Rezoning Transportation Analysis

Petition Number: 2022-118

From: Jake Carpenter, PE
Jacob.carpenter@charlottenc.gov
980-221-5675

Revision Log:	Date	Description
	12-29-22	First Review (IW)
	01-26-23	Second Review (IW)

**8835 HARRISBURG RD CHARLOTTE NC 28215**  
**REZONING**

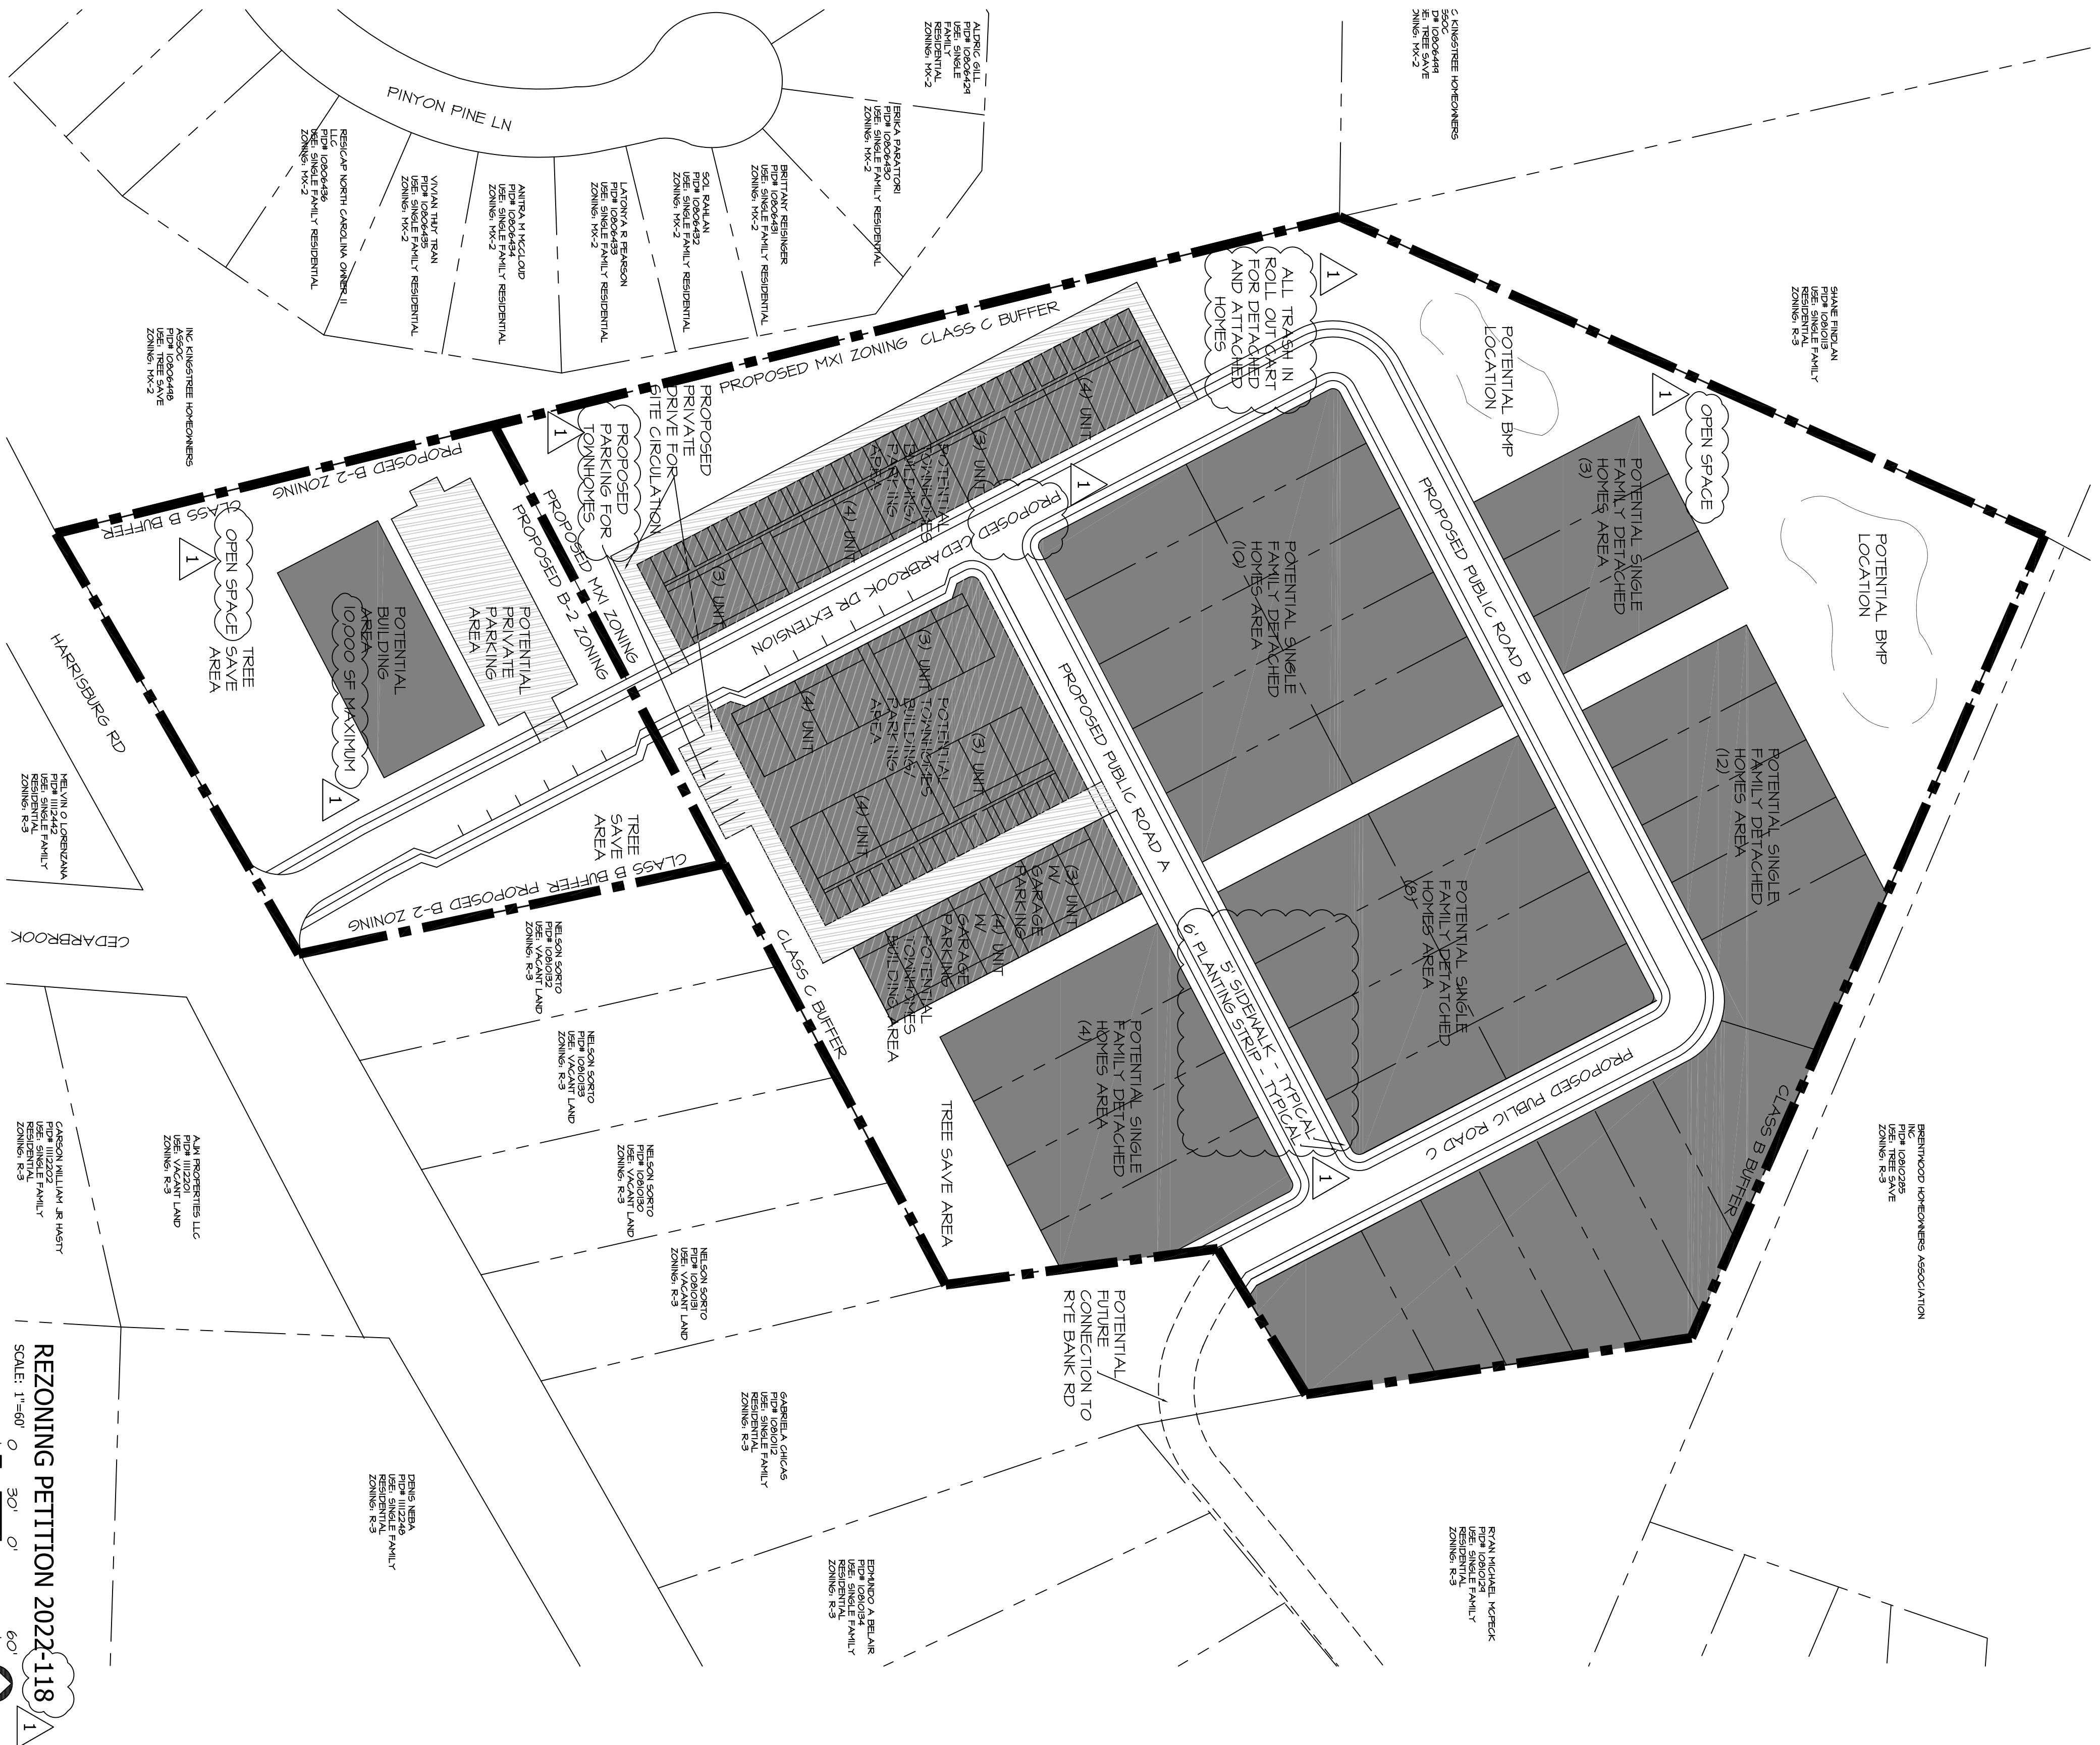
- a. **Harrisburg Road:** Location of future back of curb and gutter to be located to 30 feet from roadway centerline to accommodate the Charlotte Streets Map with a roadway typical section of CLDSM 11.09 Major Thoroughfare.

Label and dimension the curb and gutter from the centerline for each road on the site plan.

- 3. Revise site plan and conditional note(s) to commit to dedicate 52 feet of right-of-way from the road centerline. The site plan shall label and dimension the right-of-way from the road centerline.
- 4. Per Chapter 20 revise site plan and conditional note(s) to commit to construct an 8-foot planting strip, and 6-foot sidewalk on all internal public roads or if the proposed dwelling units exceeds 12 per acre after verifying density, revise site plan and conditional note(s) to commit to construct an 8-foot planting strip, and 8-foot sidewalk along all internal public Roads. The wider sidewalk also meets the Charlotte WALKS Policy.

The site plan shall label and dimension both items from the back of curb and gutter or edge of pavement.

Clarifying comment 01-26-23: After receiving updated density, the site plan and conditional note(s) should be revised to commit to construct an 8-foot planting strip, and 6-foot sidewalk on all internal public roads per the Chapter 20 ordinance.

5. Revise site plan and conditional note(s) to commit to construct bicycle facilities by installing a 12' multi-use path to meet the Council-adopted Charlotte BIKES Policy along Harrisburg Road. Multi-use paths maintained by the City shall meet ADA/PROWAG requirements.

7. Revise site plan and conditional note(s) to commit to installing a left turn lane for access off of Harrisburg Road per coordination with NCDOT.
8. Revise site plan and conditional note(s) to commit to extending stem length of Cedarbrook Drive Extension to 100 feet, no parking within that stem. Per coordination with NCDOT.

9. Revise site plan and conditional note(s) to commit to acquiring right of way prior to permit approval. Per coordination with NCDOT.
10. CDOT Request: If possible, revise site plan and conditional note(s) to commit to improving Cedarbrook Drive alignment per coordination with NCDOT.

11. Revise design of public roads to remove 90 degree turns.
